**Re: U-Haul at 8200 Jefferson St. NE
Erosion and Sediment Control Plan – C17E146 – (SWQ-2025-00051)
Engineer's Stamp Date: 12/30/25**

Based on the information in your submittal received on 12/30/25, the ESC Plan and Notice of Intent (NOI) cannot be approved until the following comments are addressed. This is the first look at an ESC Plan since it was missing from the first submittal. The ESC Plan required by the City consists of all the Storm Water Pollution Prevention Plan (SWPPP) Map requirements from the EPA's Construction General Permit (CGP) Part 7.2.4. Additional items from the SWPPP are required on the ESC Plan by the city's checklist sent with the first comment letter.

DRAWN:	GBV	
CHECKED:	ARA	CO-10
DATE:	12/03/25	
CO-TITLE

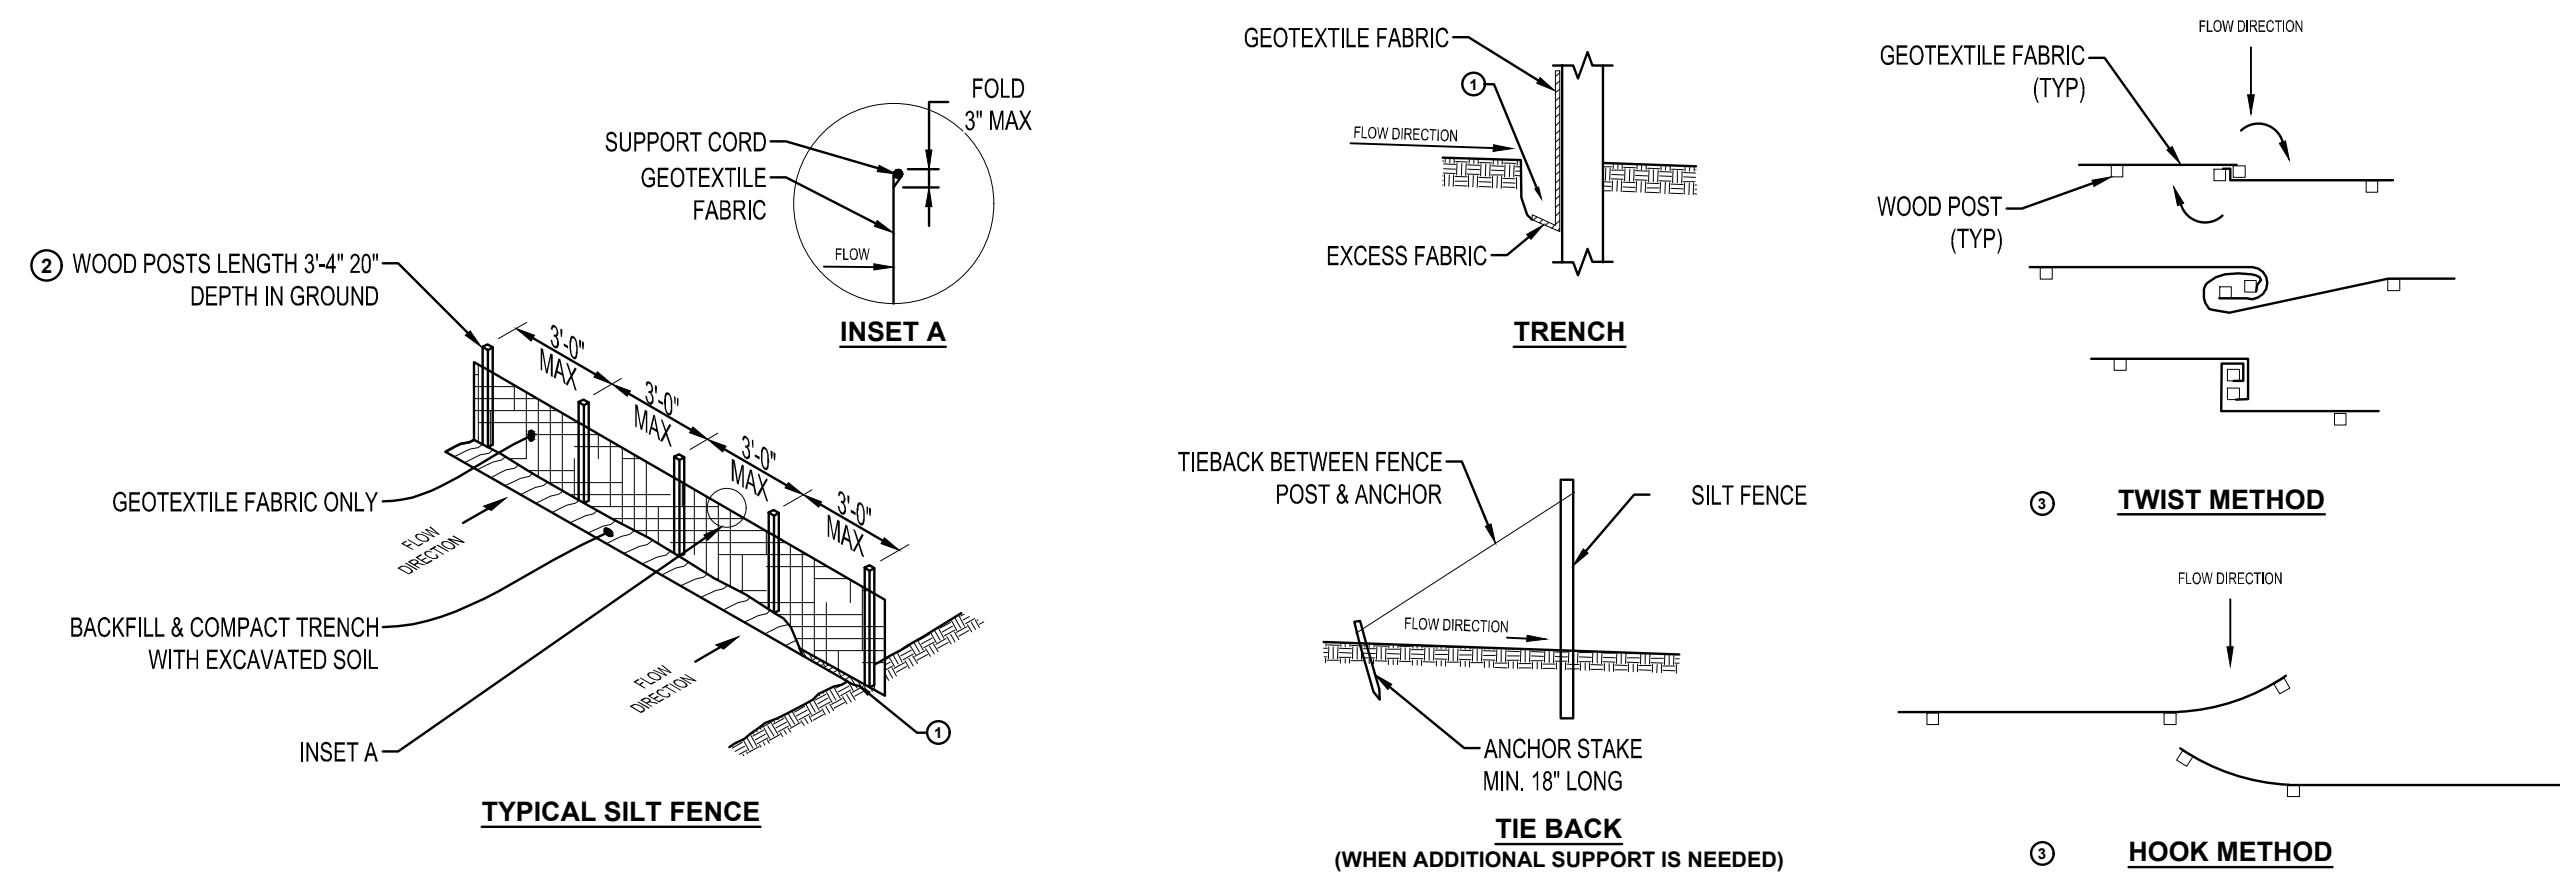
2. The cover page, Sheet C0-10, includes Site Data that doesn't pertain to the Erosion and Sediment Control (ESC) Plan except that it has a vicinity map and a sheet index. Street names must be added to the vicinity map. The index lists four sheets pertaining to the SWPPP, but the SWPPP Notes, sheet C1-10, are missing from the plan set and may contain information required on the ESC Plan. The extraneous sheets must be removed from the ESC Plan index. The ESC Plan isn't part of the Building Permit plan set; it is a separate, standalone plan that must be kept with the SWPPP during construction. The sheets should be numbered sequentially, for example: for a three-page set of plans, they would be numbered 1 of 3, 2 of 3, and 3 of 3.

DRAWN:	GBV
CHECKED:	ARA C1-20
DATE:

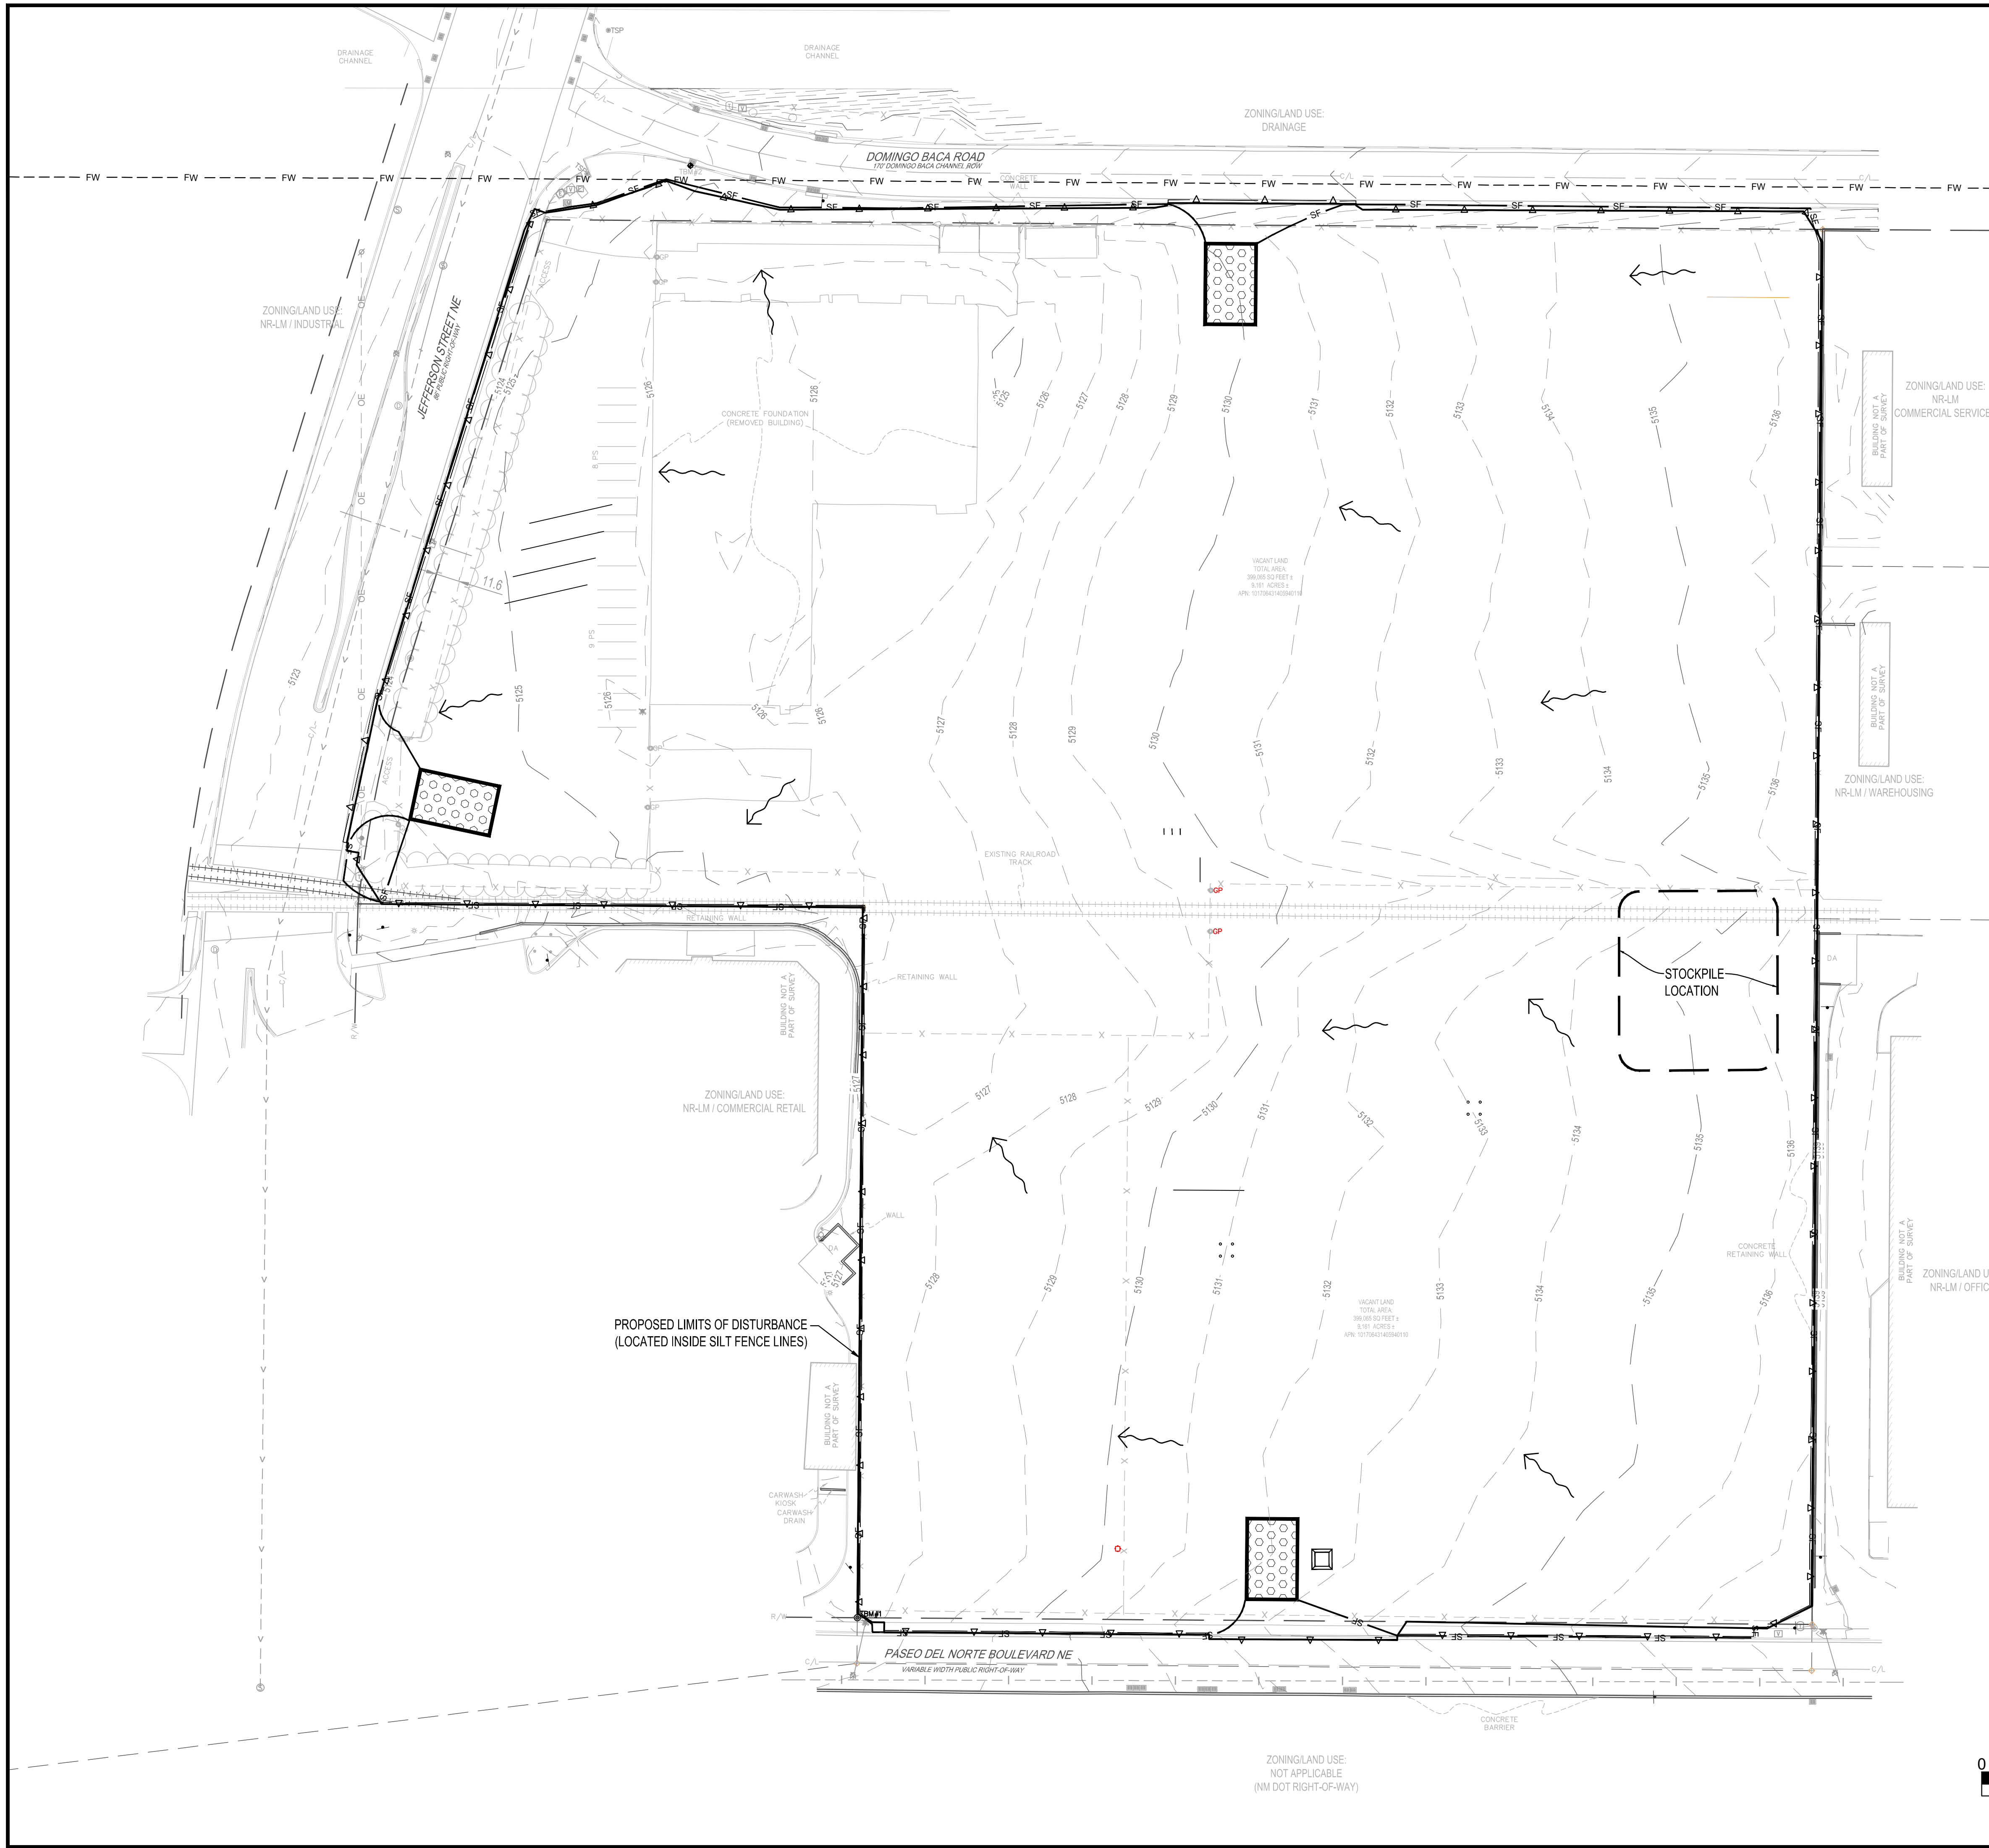
3. The BMP details on the SWPPP Details, sheet C1-20, are substandard because they are missing the design specifications, maintenance schedules, and criteria for inspections as required by CGP 9.4.1.c.i. You must *"design and install all stormwater controls in accordance with good engineering practices, including applicable design specifications"* per CGP 2.1.3. Please replace the BMP details in the ESC Plan with standard details that include design specifications, construction specifications, maintenance schedules, and inspection criteria.

DRAWN:	GBV
CHECKED:	ARA C1-40
DATE:	12/03/25

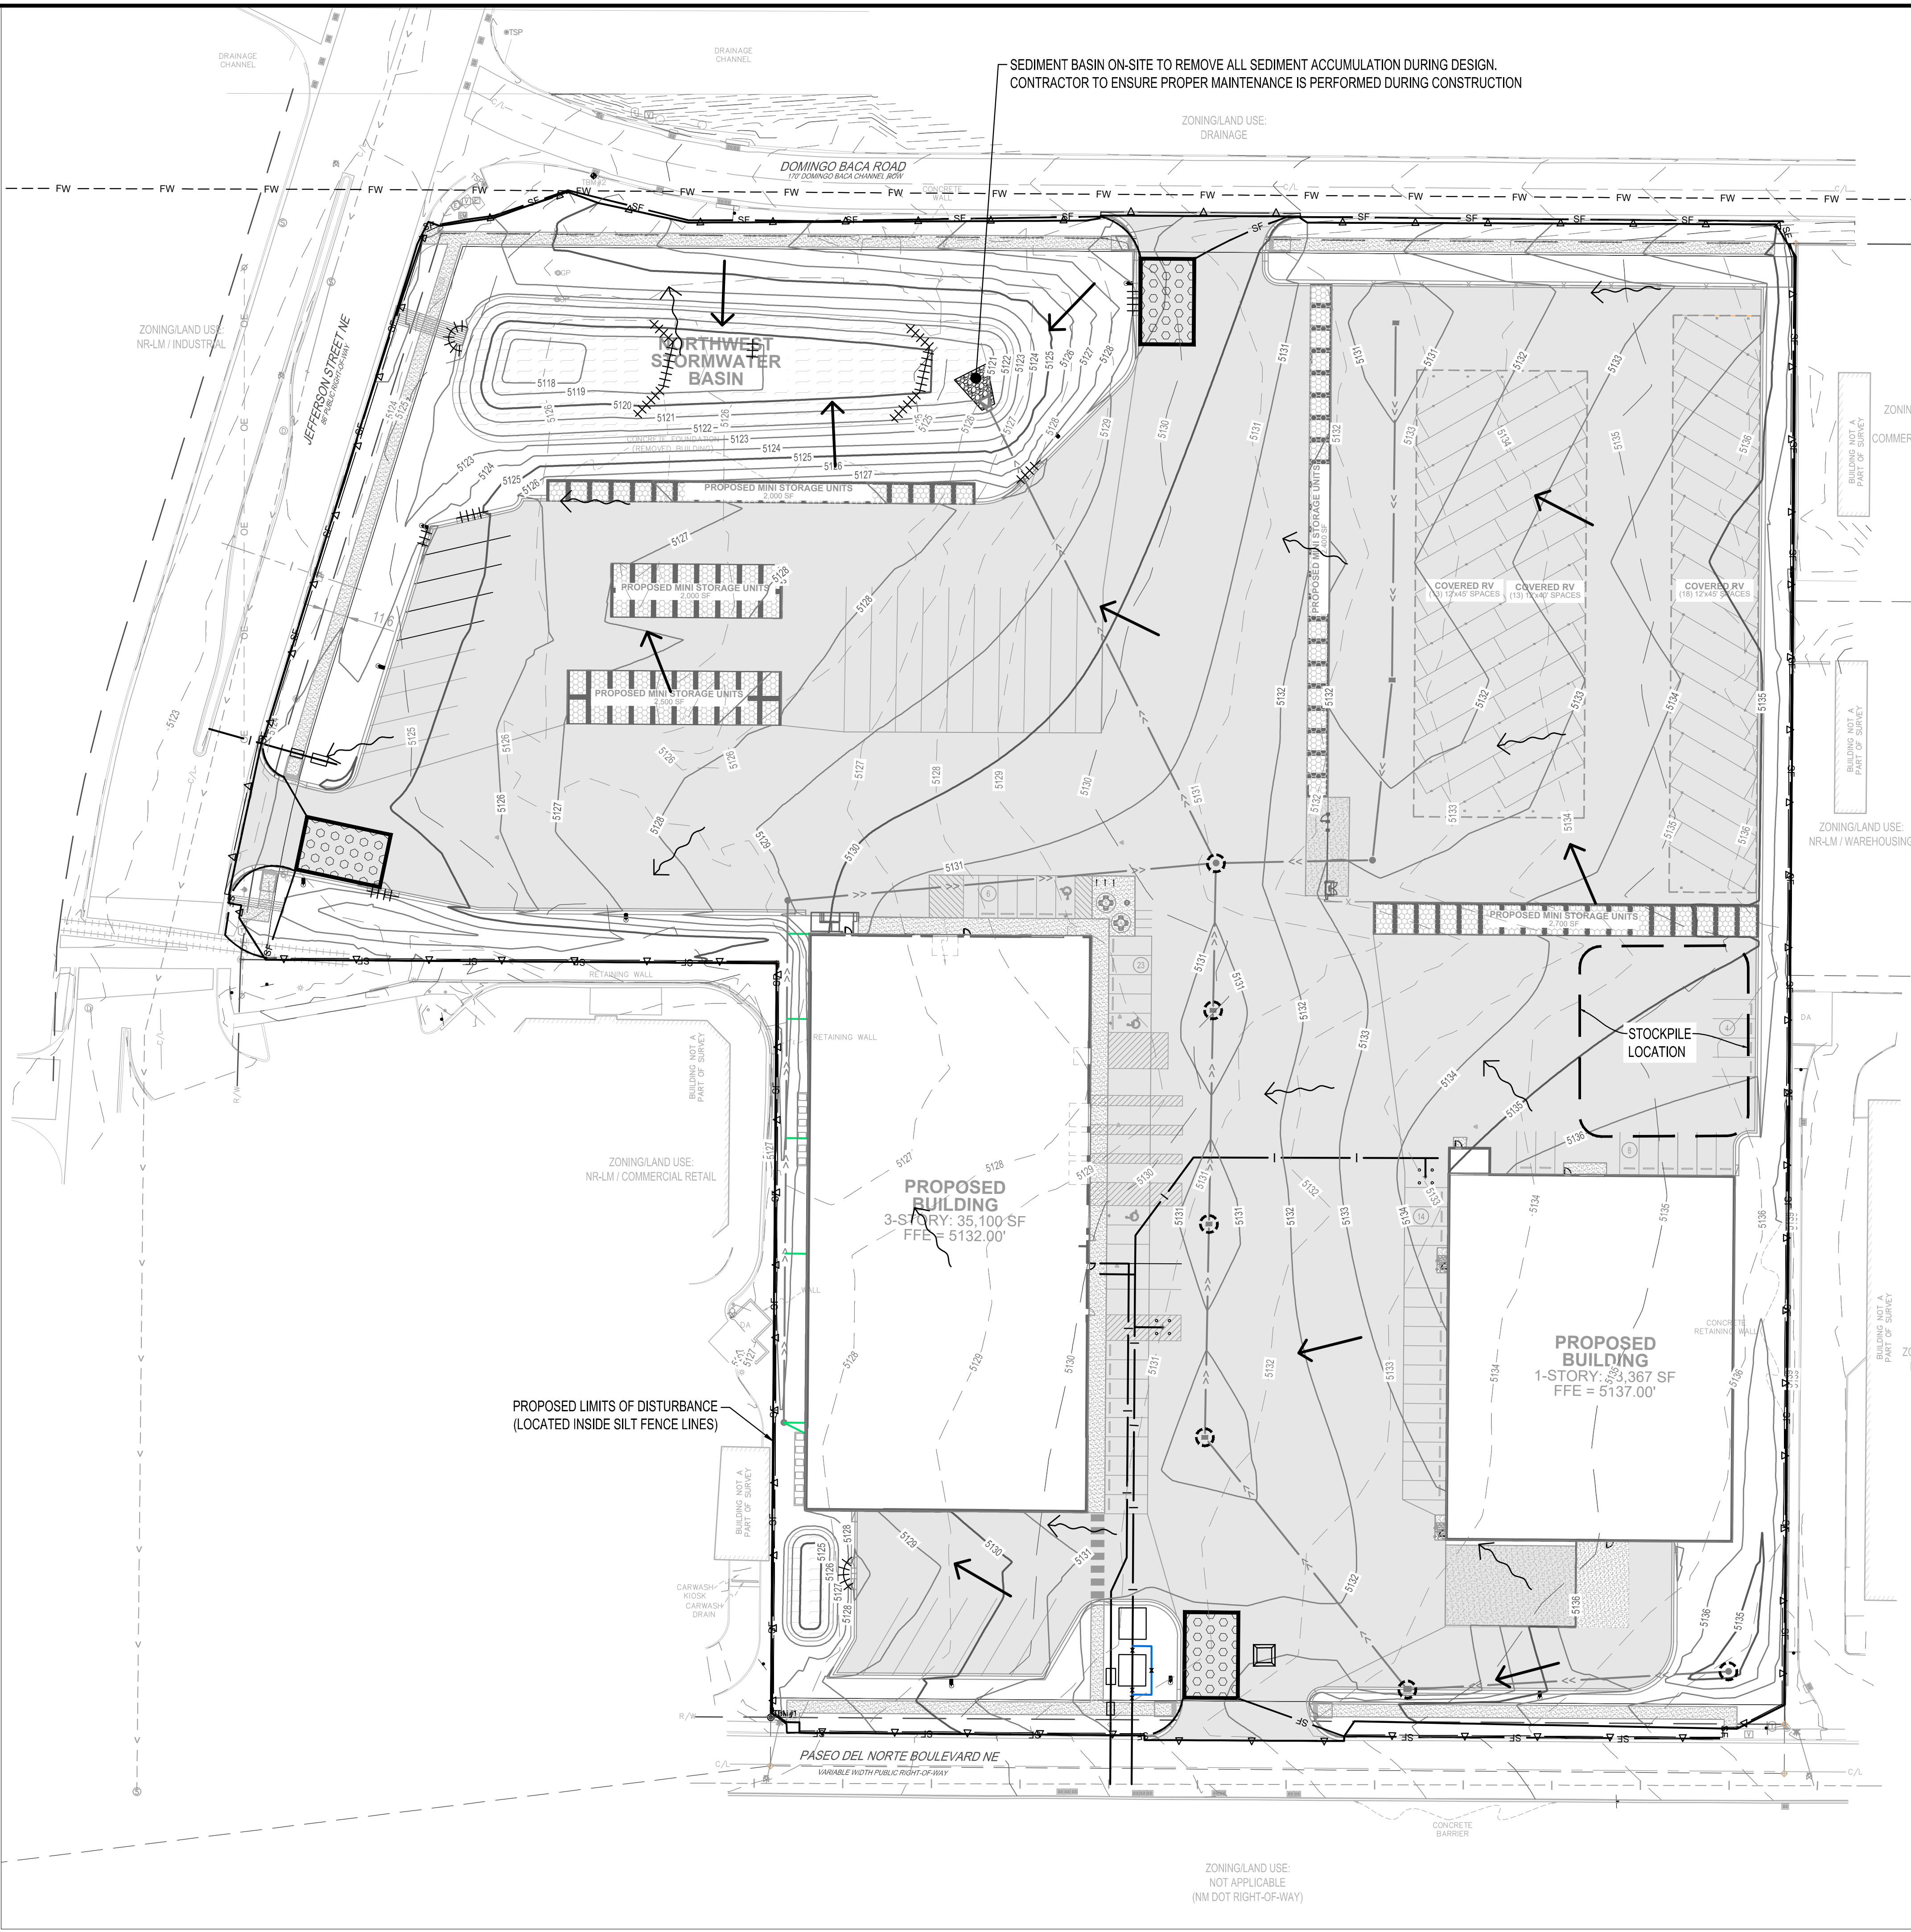
4. Sheets C1-30 and C1-40 have a note at the bottom of the ESC Plan Check List that says, *“sediment basin: drainage basin shall provide the calculated volume of 3,600 cf per acre of drainage area. 8.54 ac drainage area and requires 30,744 cf (31,724 cf provided in northwest detention basin).”* The post-construction pond probably has the temporary volume required for the worst-case scenario during construction, but the calculations are inaccurate and incomplete. A temporary conveyance system must also be designed because most of the site doesn’t naturally drain to the pond. The NMED requirements in CGP 9.6.1.c.i state: *“The SWPPP must identify and document the rationale for selecting these BMPs and/or other controls. The SWPPP must also describe design specifications, construction specifications, maintenance schedules (including a long-term maintenance plan), criteria for inspections, and expected performance and longevity of these BMPs. For sites greater than 5 acres in size “BMP selection must be made based on the use of appropriate soil loss prediction models or equivalent generally accepted soil loss prediction tools,”* and part 9.6.1.c.iii states: *“All SWPPPs must be prepared in accordance with good engineering practices by qualified (e.g., CPESC certified, engineers with appropriate training) erosion control specialists familiar with the use of soil loss prediction models and design of erosion and sediment control systems based on these models.”* Documentation is required on the ESC Plan. Include soil information – add a table with name type, particle sizes, and Erodibility factor per CGP 2.1.1. Also identify and document the rationale for selecting these BMPs and/or other controls per CGP 9.6.1.c.i. Add a narrative description and soil-loss calculations to the ESC Plan.

5. The stormwater controls are inadequate. Silt Fences (SF) on sheets C1-30 and C1-40 are not effective stormwater controls for the large drainage areas and concentrated flows on this site, although they are still necessary for fugitive dust control. Diversion Channels (DC) and Sediment Traps (ST) are required along the west edge of the area of land disturbing activity and must be included with the stormwater controls installed as the initial construction items. The Construction Exit (CE) on the west side of the site conflicts with the need for a Diversion Channel (DC) on the same side to direct stormwater to the large ST in the northwest corner. Therefore, the CE should be removed from the ESC Plan, and design calculations for the DC and ST must be added to the plan. Consider installing an interim DC along the low side of the new storm drains as the first step in construction to control stormwater until the storm drains are built. Also, consider adding a retaining wall at the west property line next to the new building as support for a DC. Include a cross-section of the DC on the west side of the building. The ESC Plan must specify how and when stormwater will be directed into the ST(s). Additional STs may be required. Follow the design specifications and ESC Plan requirements outlined in the attached draft DC and ST details or equivalent details. The building floor elevation is 5’ higher than the adjacent natural ground elevation. Provide a Typical section(s) showing how the Diversion Channel will contain stormwater during each phase of the sequence. The DC may have to be relocated several times.
